OXFORDSHIRE COUNTY COUNCIL'S RESPONSE TO CONSULTATION ON THE FOLLOWING DEVELOPMENT PROPOSAL

Application no: 23/03073/HYBRID

Proposal: In FULL, the construction of an 82-apartment affordable extra care home (C2 use class) with associated openspace / green infrastructure, landscaping, car / cycle parking, service infrastructure (drainage, highways, lighting), engineering operations, creation of new vehicular access and re-instatement of existing access to footpath, and in OUTLINE, the construction of up to 14 residential (C3 use class) dwellings with associated landscaping, service infrastructure (highways, drainage, lighting)

Location: Phase 2 SW Bicester Kingsmere Parcel R East Of, Ludlow Road, Bicester

Revision: P25

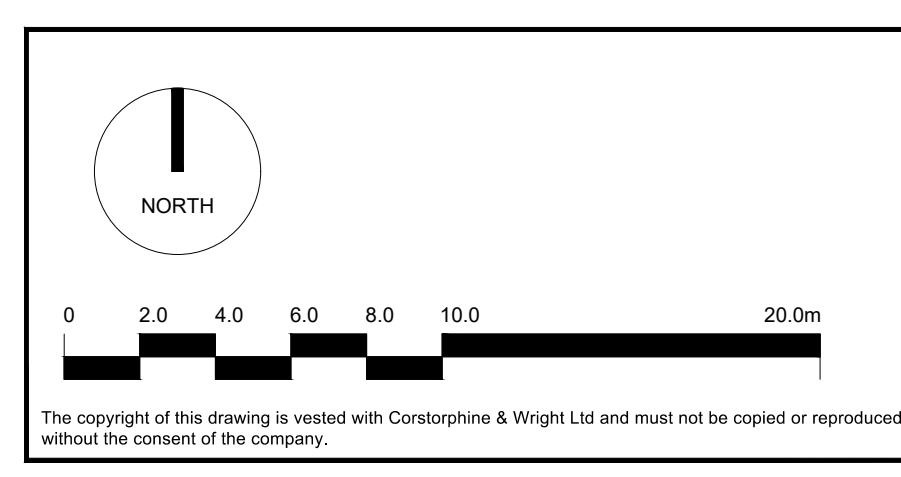
The OCC Highways Agreement team have requested the specific plans detailed in the Road Safety Audit (dwg no. 21413-CWA-BC-XX-DR-A-2011 P15).

The drawing contained within the revised note is revision reference P25 not P15. There is also another plan with revision reference P26. Clarification is sought as to the final plan version. Without seeing the plans used within the audit they are unable to confirm / agree with the outcomes of the audit.

Insert 3.1 Proposed Pedestrian Connection

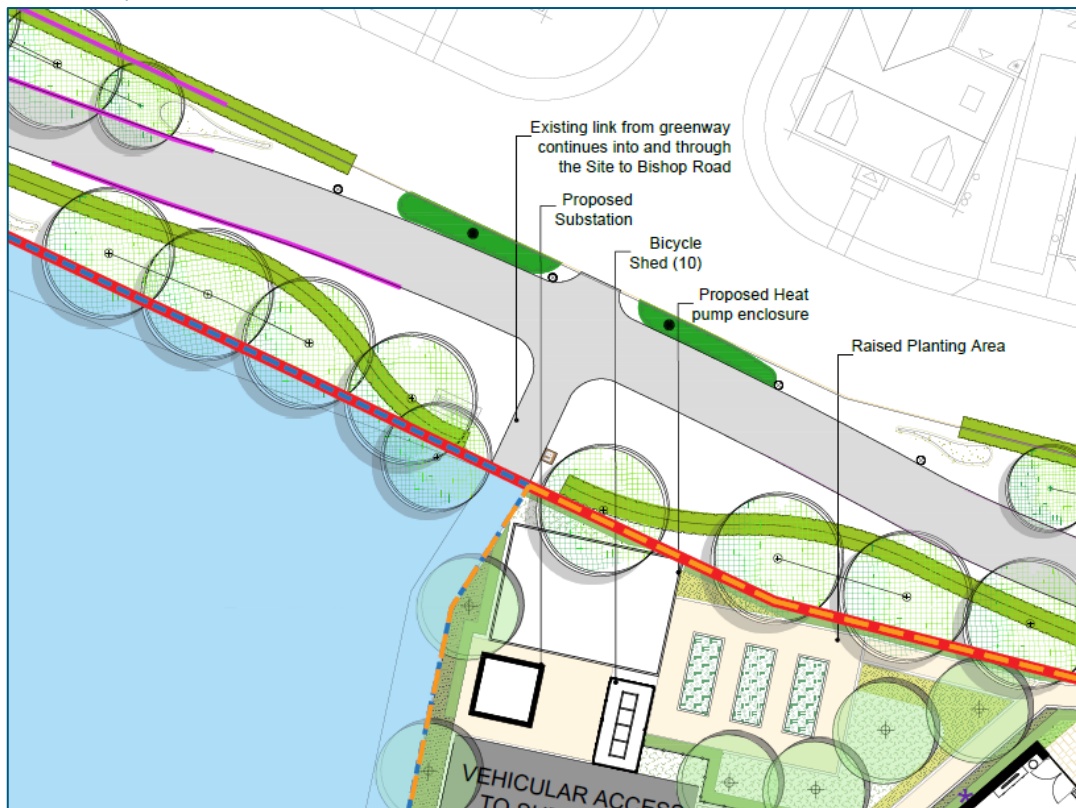
A pedestrian / cycle link to the northwest of the site (near the turning head / substation), connecting to the residential access should be provided / suitably conditioned.
